29/11/2019

**Meadowbank Education and Employment Precinct Schools Project (SSD-9343)
Request for Response to Submissions**

Karen Harragon
Director, Social and Infrastructure Assessments
as delegate for the Secretary

2.1m High fixed fence with planting to boundary

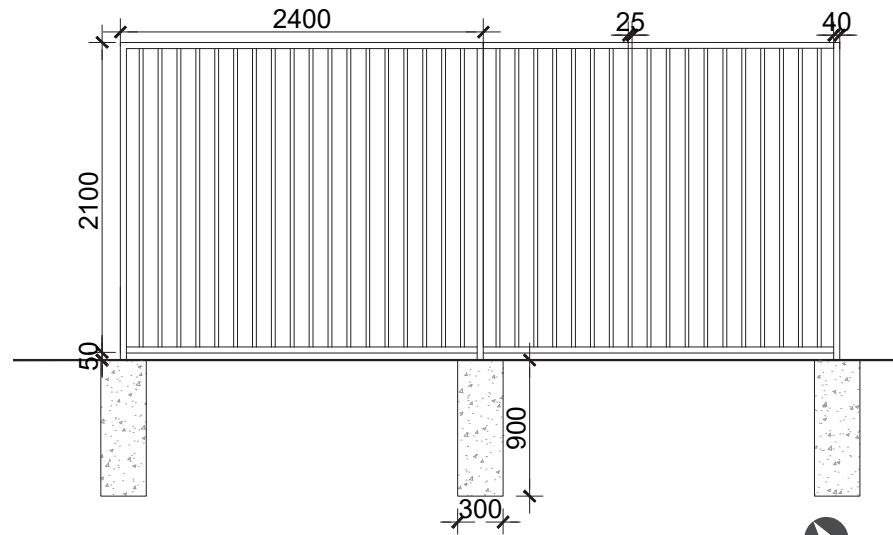
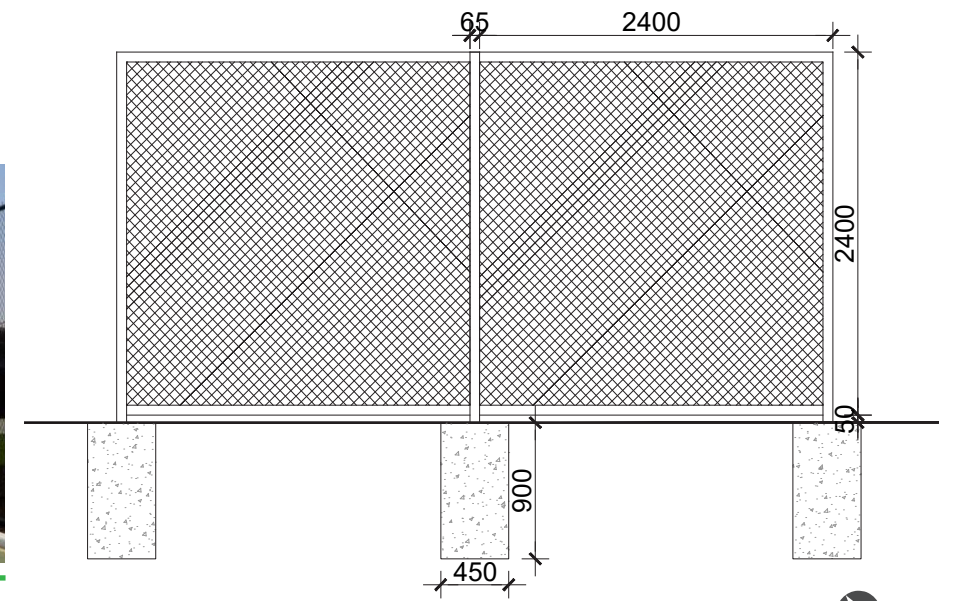
5. Provide design details of the proposed '2.1m high vehicle bar railing' and 2.1m high sports field/courts fence'.
6. Provide landscaping drawings at a higher resolution so that their legends are legible.

GRASS SWALE/ DEPRESSION DETAIL PLAN AND SECTIONS

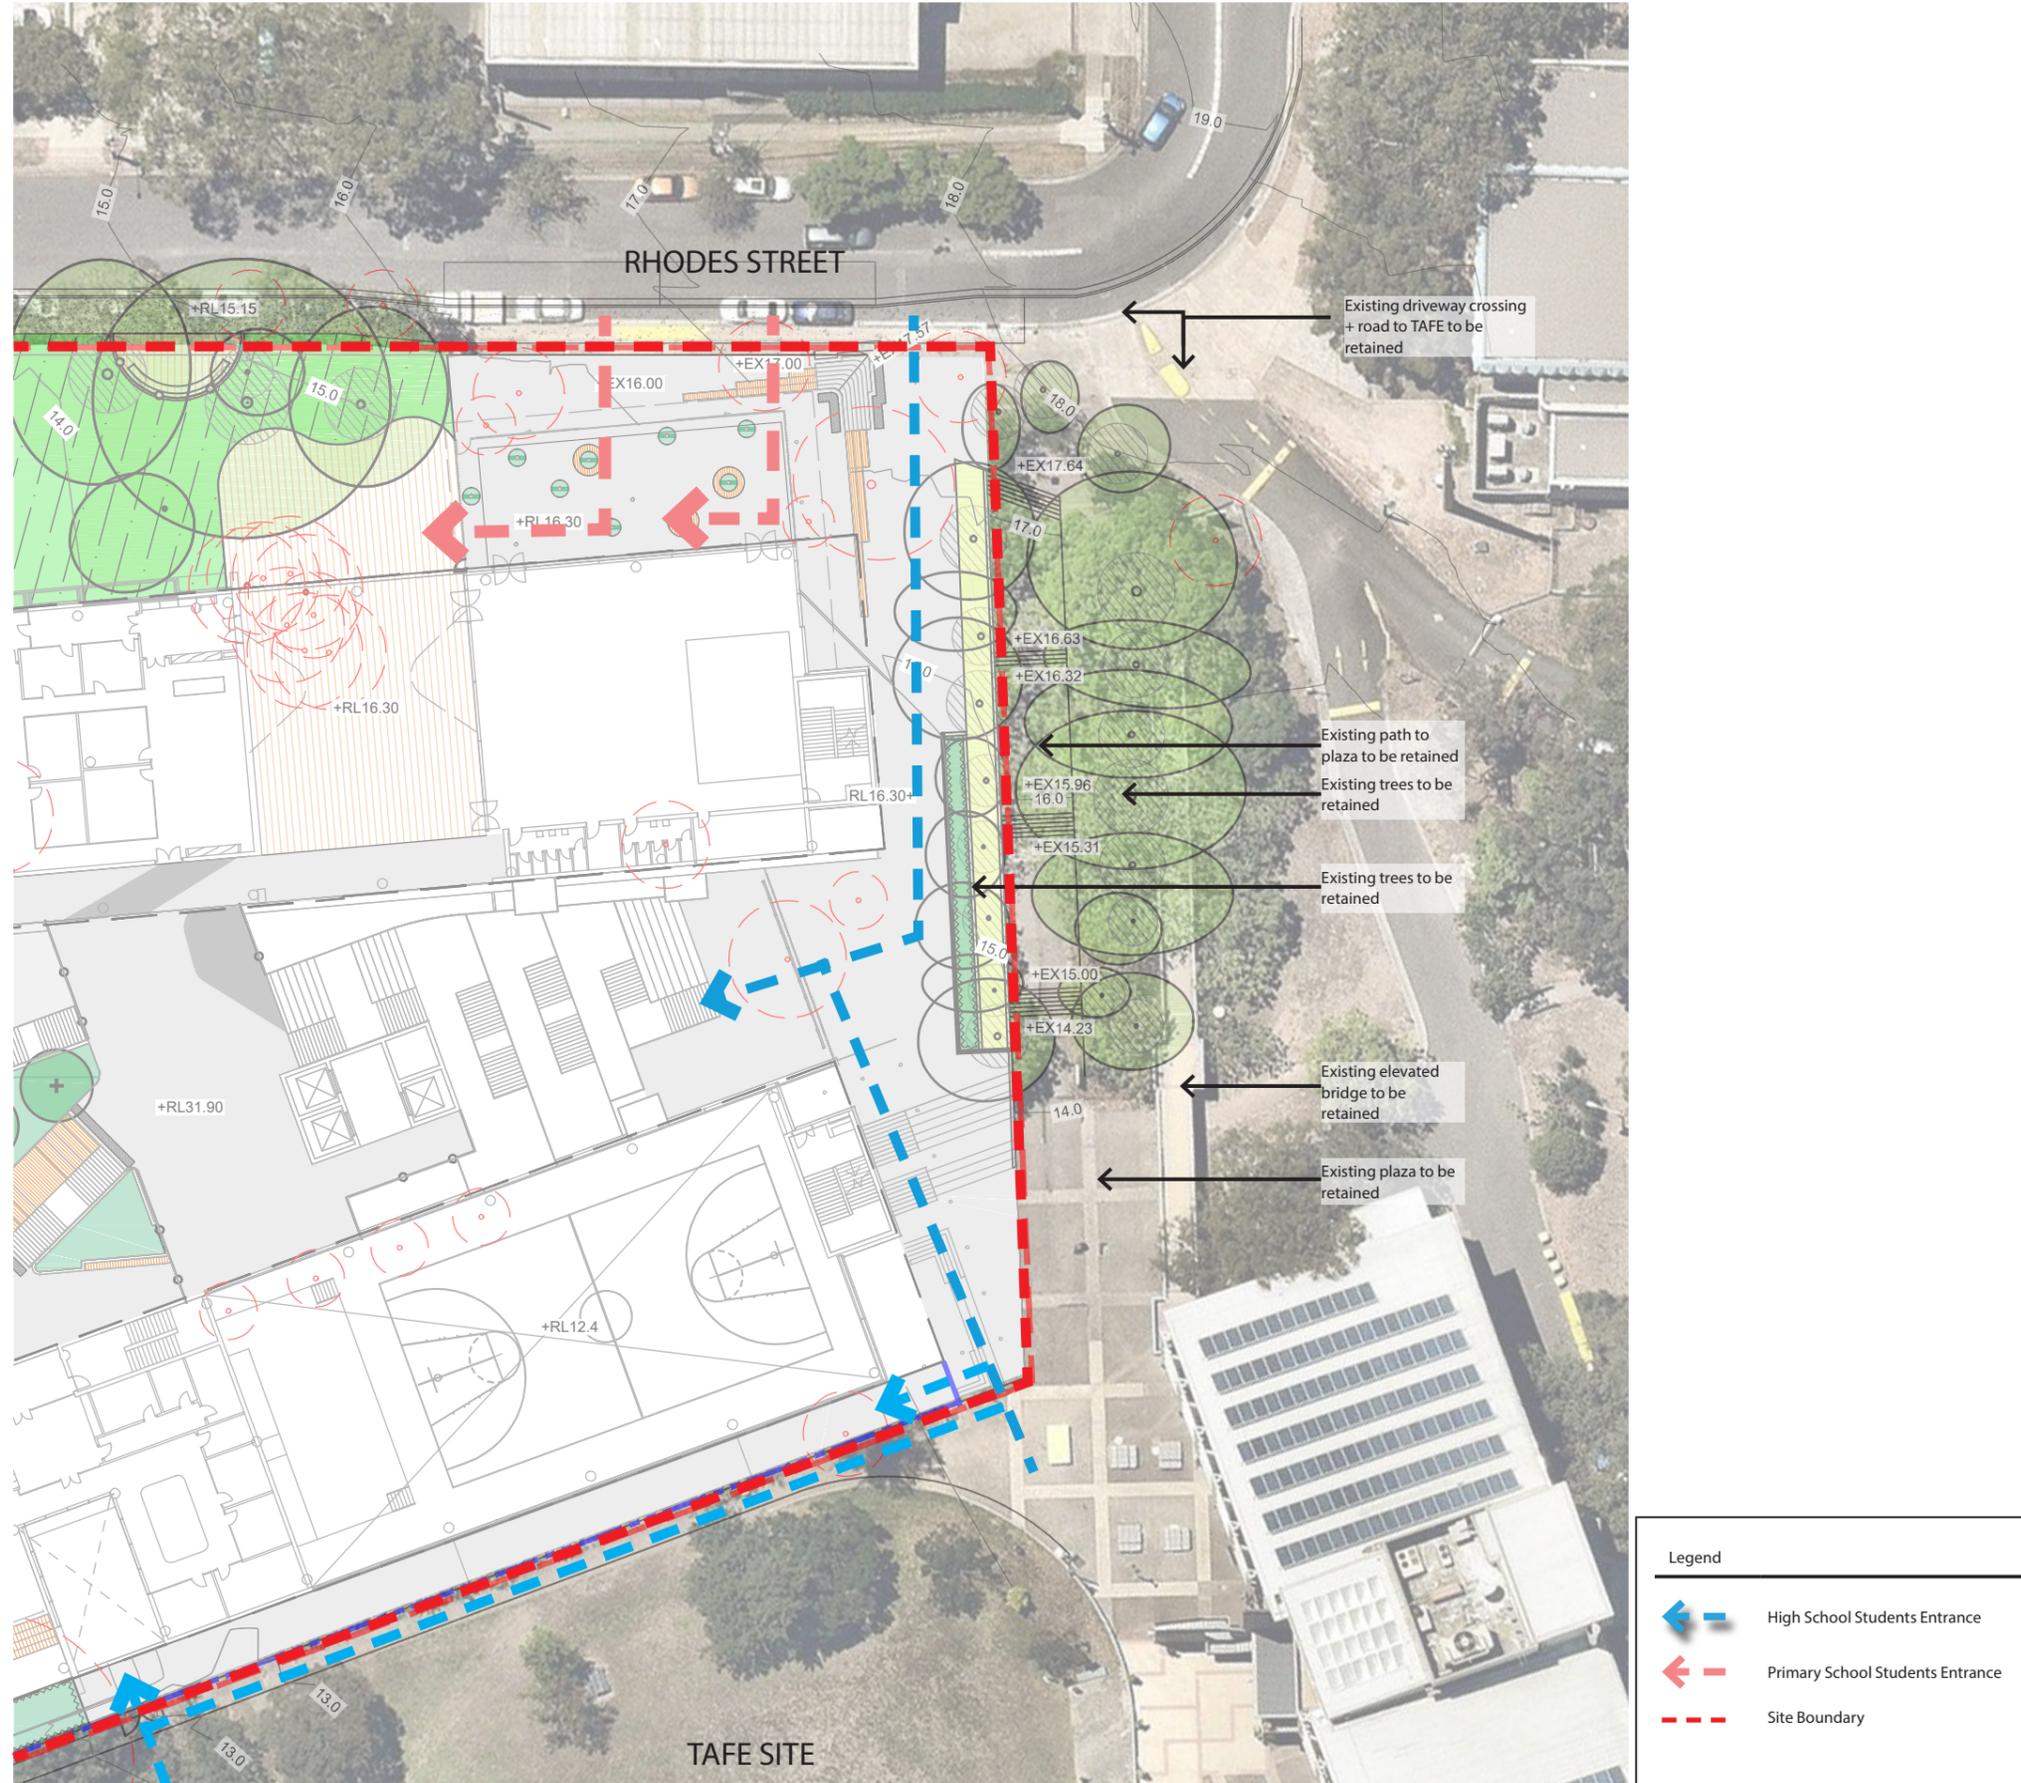
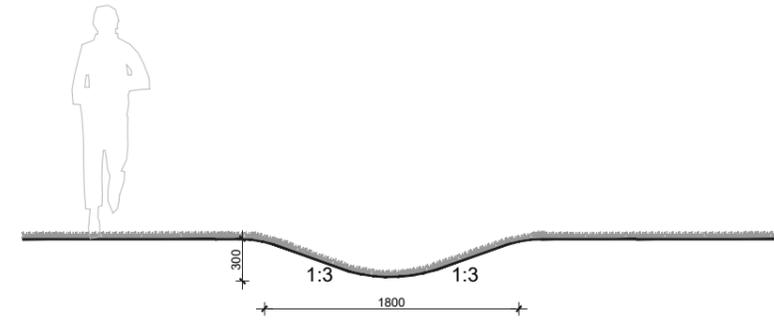
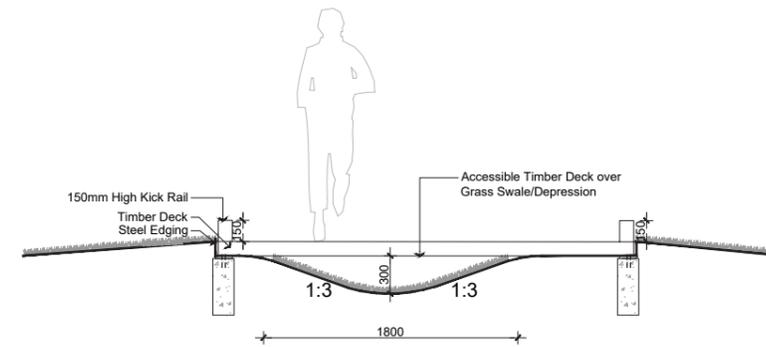
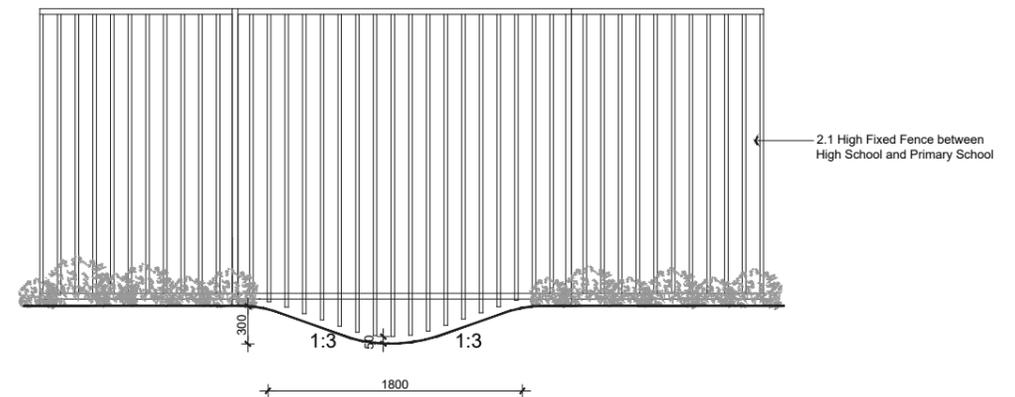
9. Provide an assessment of the viability of the proposed tree planting proposed above structure within the Central Landscape area. In addition, provide greater detail of the planter dimensions, soil depth and maintenance.
10. Provide greater detail of the proposed swale that runs north/south through the site, including consideration of management and student safety.
